CITY OF ALBUQUERQUE

May 17, 2019

**Re: McDonald's – 8315 Montgomery Blvd
Erosion and Sediment Control Plan
Engineer's Stamp Date 4-4-19 (F19E013A)**

GRADING PLAN

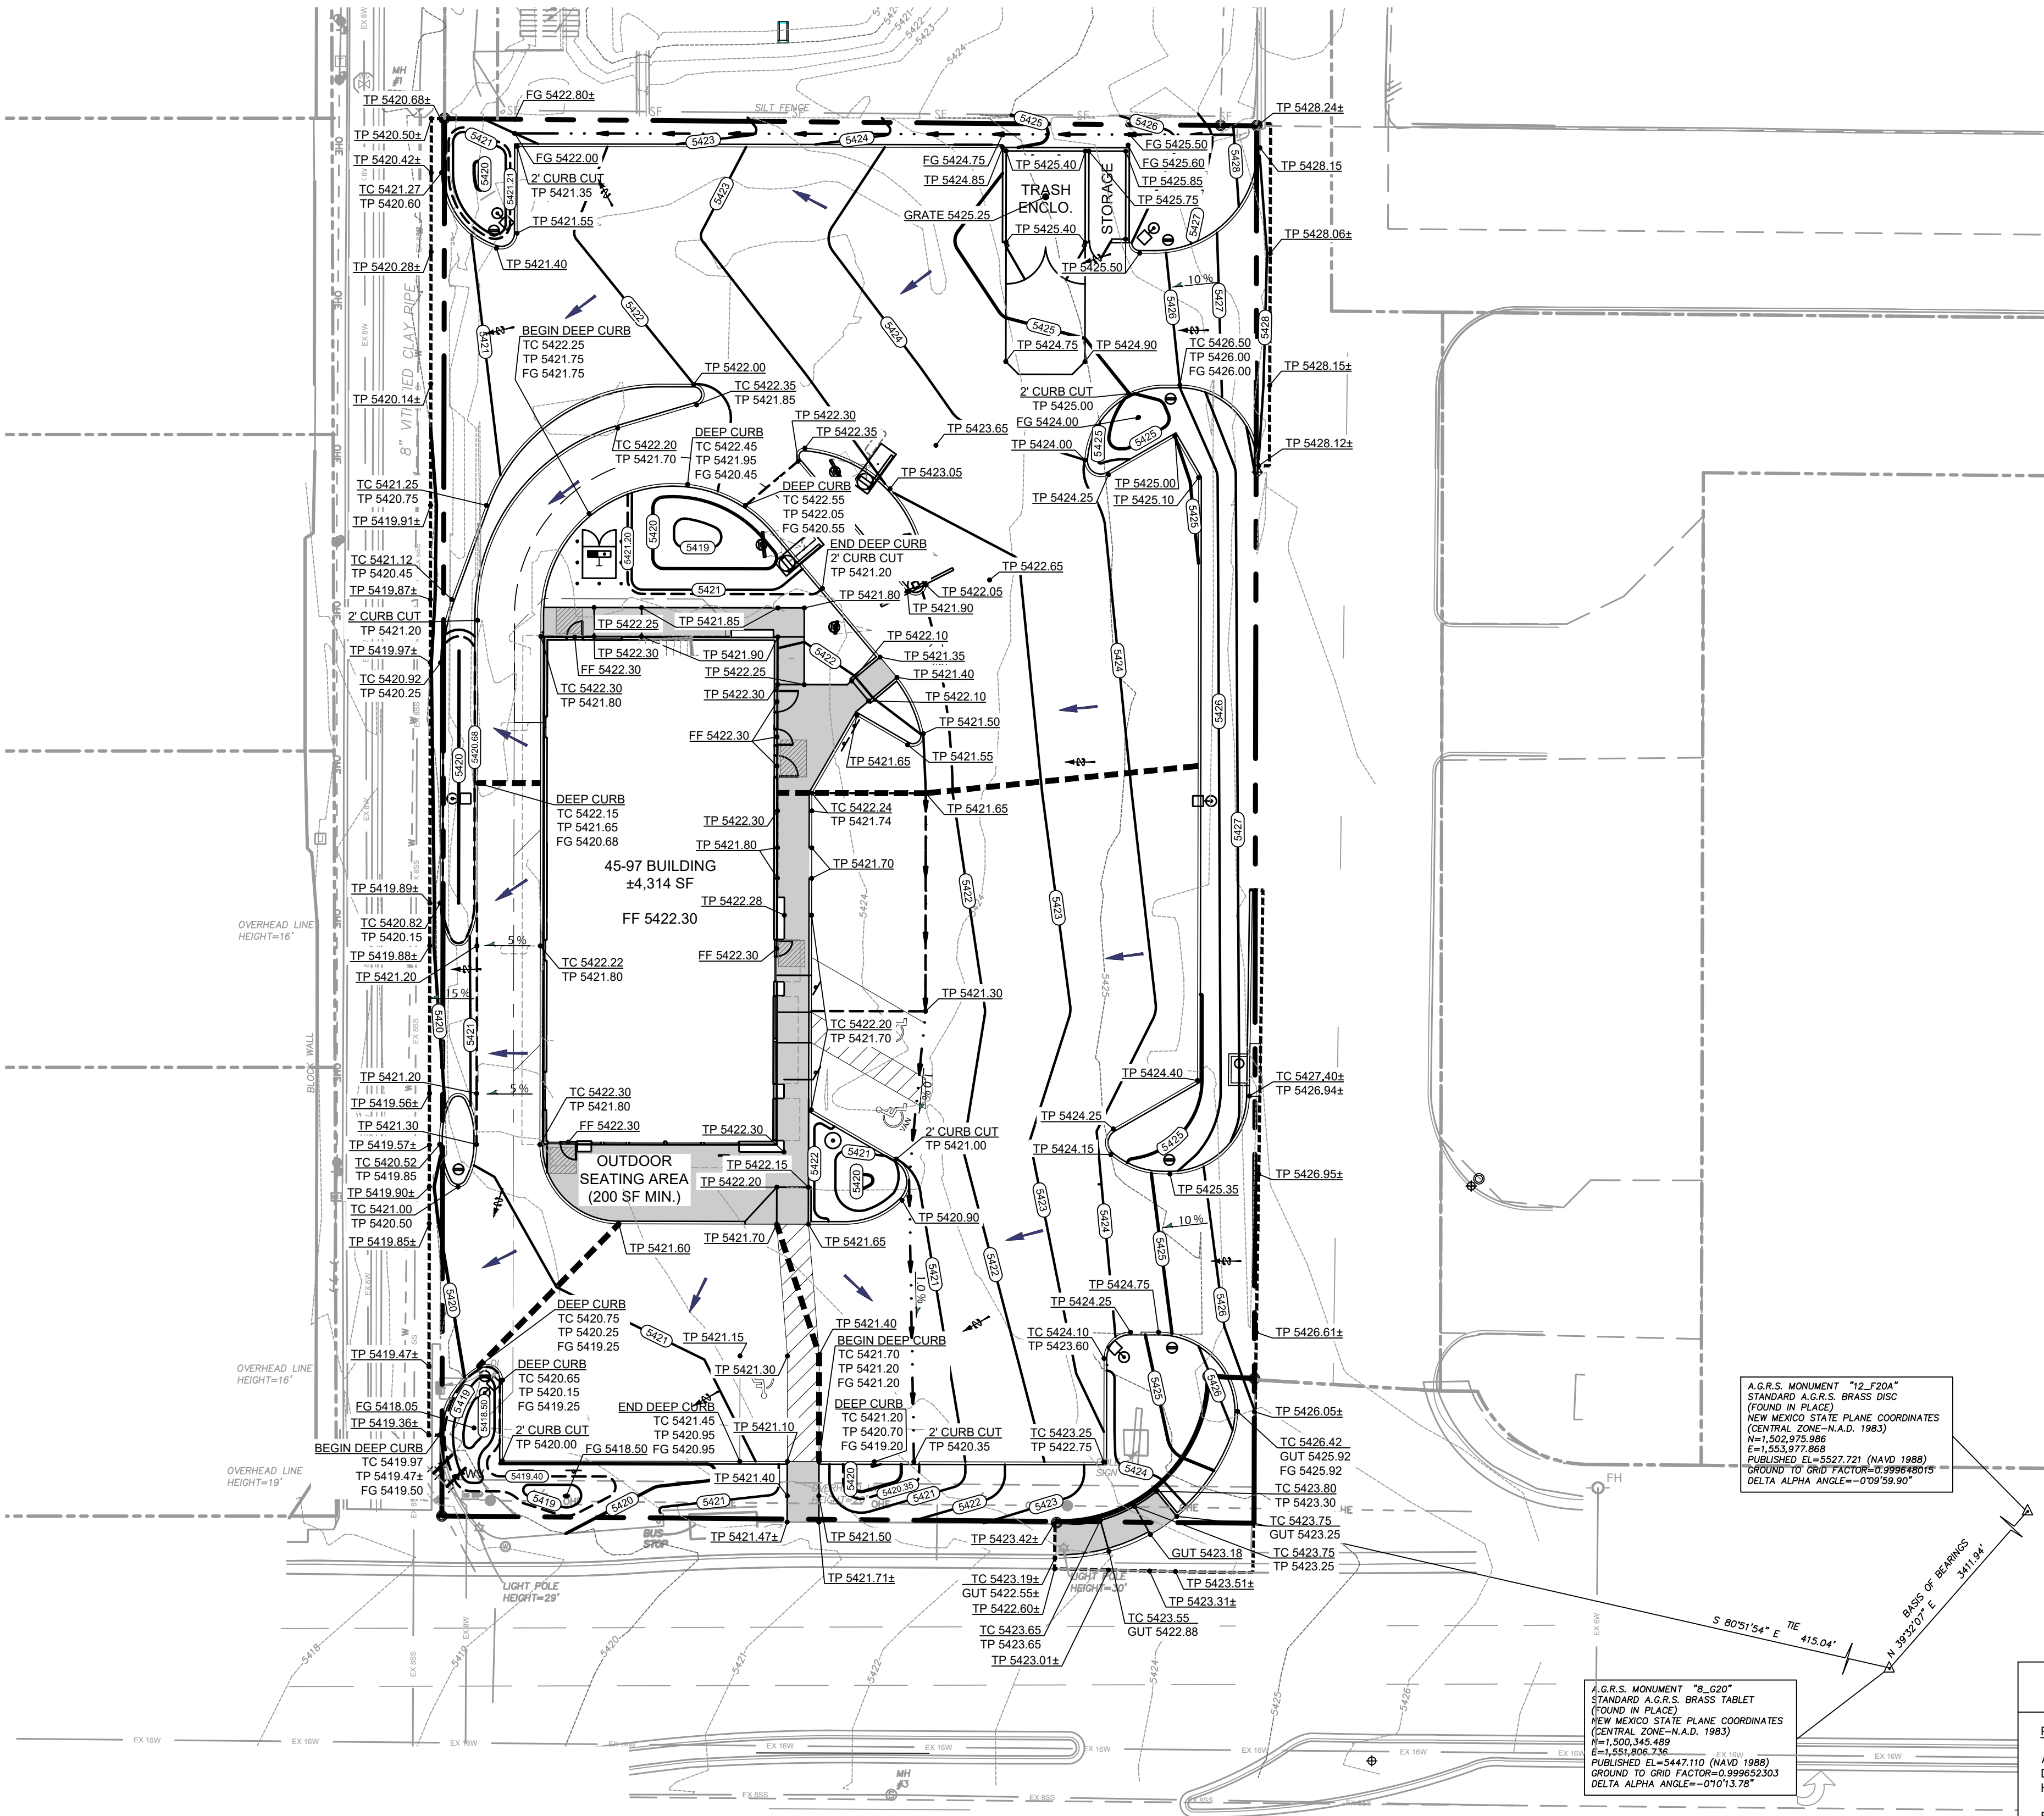
1. There is no dimension for the height of the rock check dam or for the size of aggregate to filter the stormwater.

a. Rock check dams can filter stormwater, but the appropriateness of using this type of BMP at a small construction site is not apparent as it has a large footprint which may interfere with grading/demo operations and it is cannot be temporarily removed/reinstalled which may be necessary for the utility connections in the alley or similar.

b. Stormwater Quality would recommend filter /mulch socks since the existing surface is asphalt. Once the demo is complete a filter/mulch sock or silt fence (depending on cut/fill) may be appropriate.

2. Provide existing grades. This assists Stormwater Quality in determining cut/fill at the edges of the site which helps determine the appropriate sediment BMP. An example is that if 2 feet or more of fill is proposed on an edge of the site a filter/mulch sock will not be appropriate as it will be overwhelmed by the amount of fill adjacent to it.

3. A straw wattle is proposed in a drive lane of Montgomery Blvd and at the south end of the alley. See comment 1.a above.

4. A rock check dam is proposed near the northeast corner of the site, which is uphill. Stormwater Quality recommends removal of this proposed BMP.

5. Stormwater Quality realizes that the access easement on the east side is on the uphill side of the site. However, it is difficult to demo/grade along an edge without sediment leaving the site. Stormwater Quality recommends a filter/mulch sock along the eastern edge of the site except where the construction entrance is proposed.

6. In the existing condition there is a retaining wall along the alley along the western edge of the site. See comment #2 above.
